Your ref:
Our ref: 24/00420/F
Please ask for: Mrs Lesley Raby
Direct dial: 01553 616818
E-mail: borough.planning@west-norfolk.gov.uk

TOWN AND COUNTRY PLANNING ACT 1990

Details: **Retrospective Change of use of 5 former farm buildings to 14 units for industrial and storage uses B2, B8 and E(g)(iii). at Park Farm Castle Road Wormegay KINGS LYNN Norfolk**

floor plans  
28/3/24

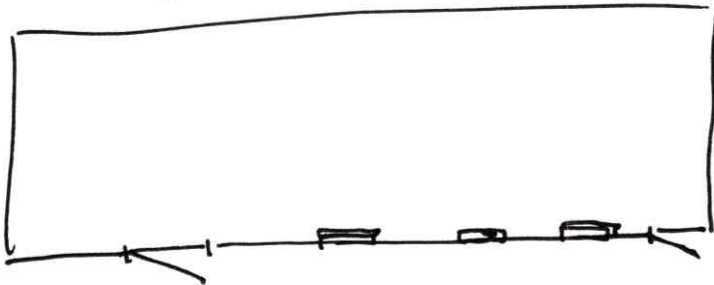
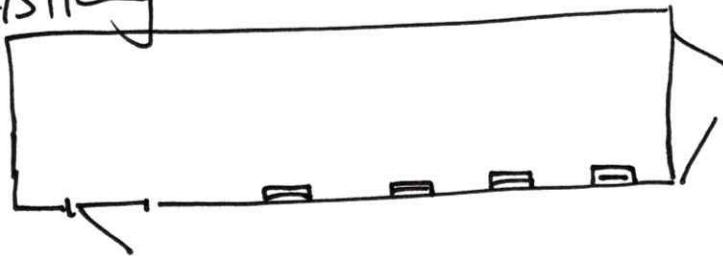
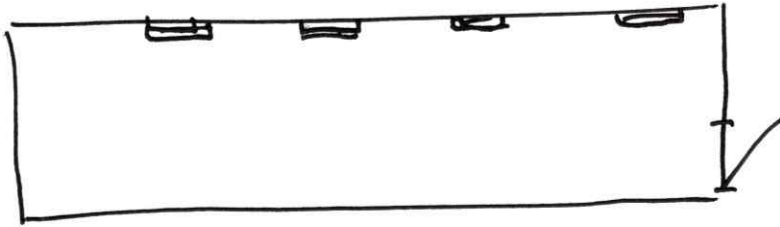
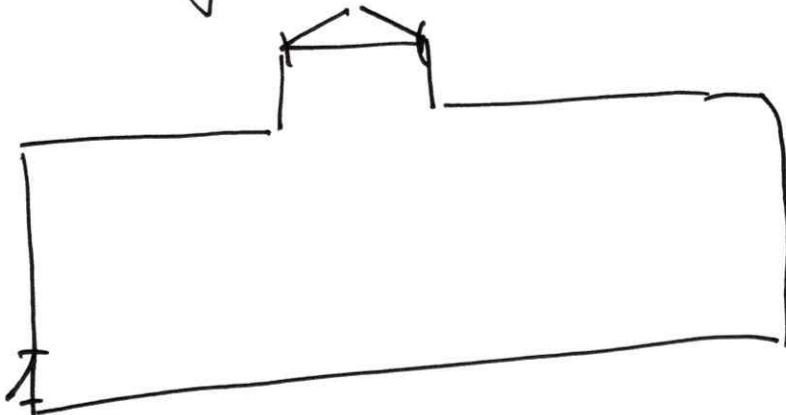
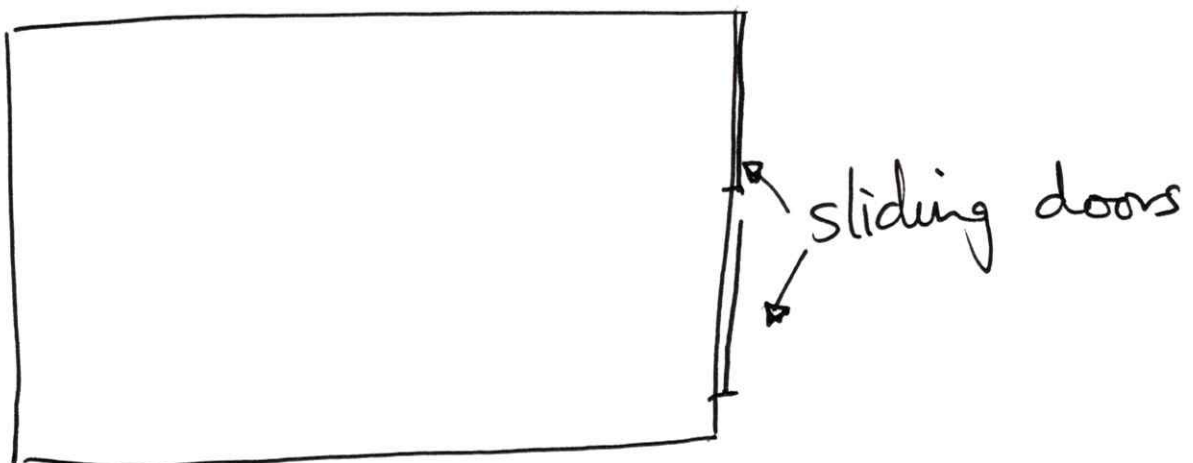
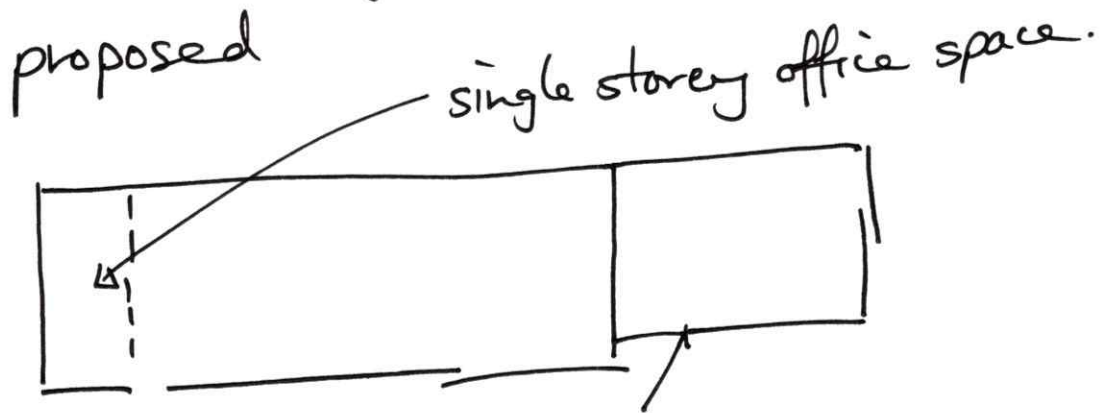
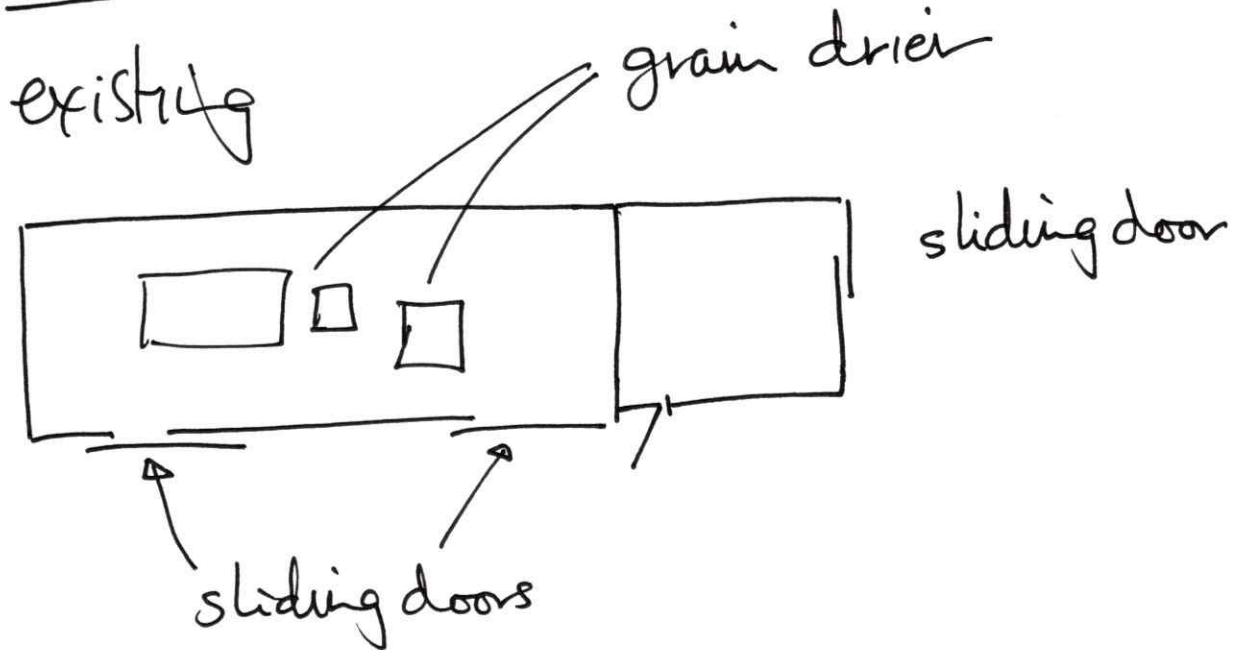
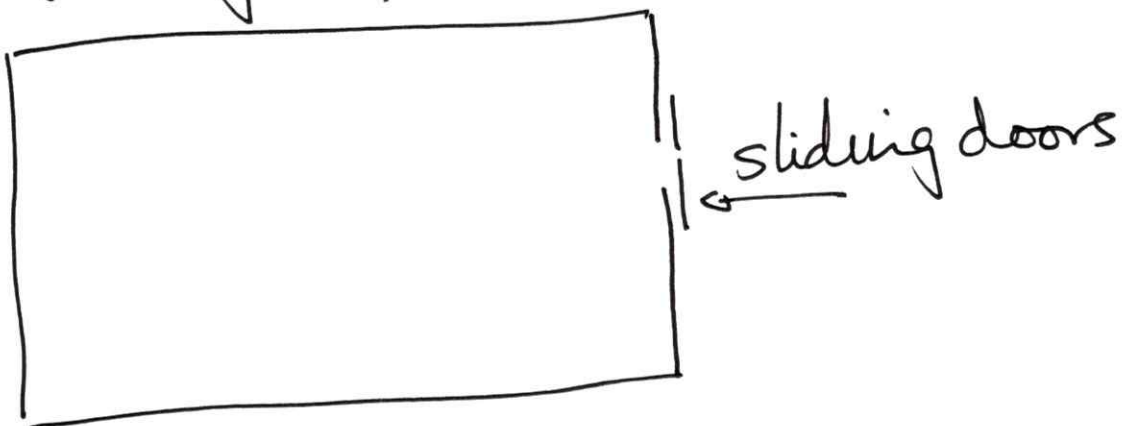
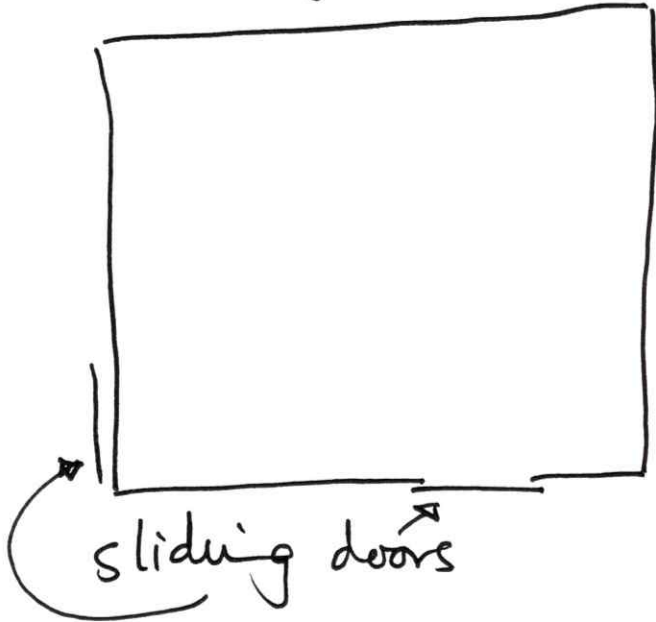
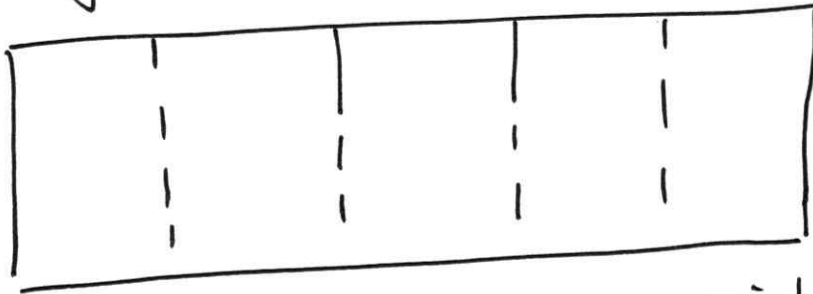
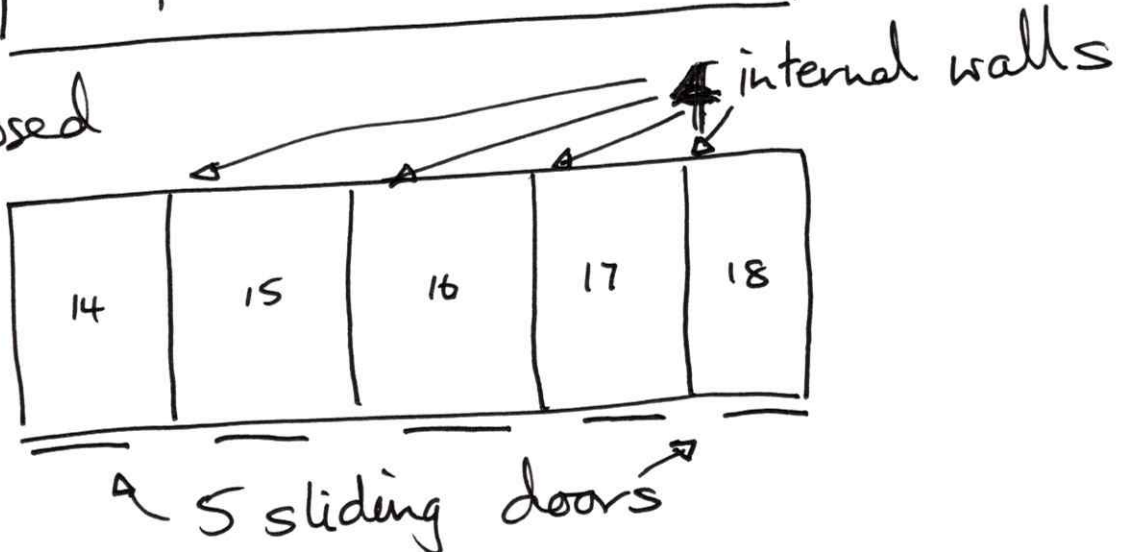
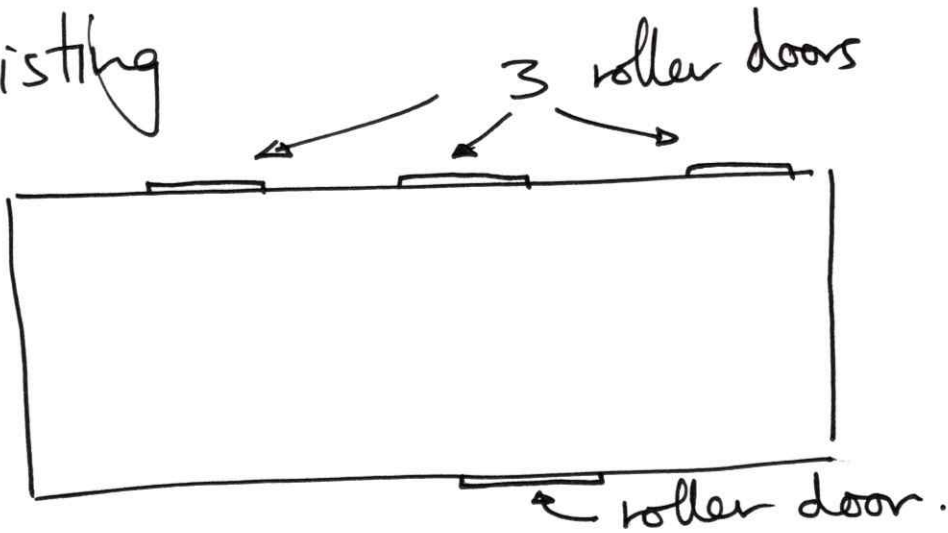
1. Provide the existing and proposed floor plans relevant to these buildings.

Confirm that there have not been any external changes made to these buildings.
2. As the property lies within an area at risk to flooding, please complete the simplified Matrix and return it. The Matrix can be found at https://www.west-norfolk.gov.uk/info/20173/information_for_planning_agents/231/flood_risk_information
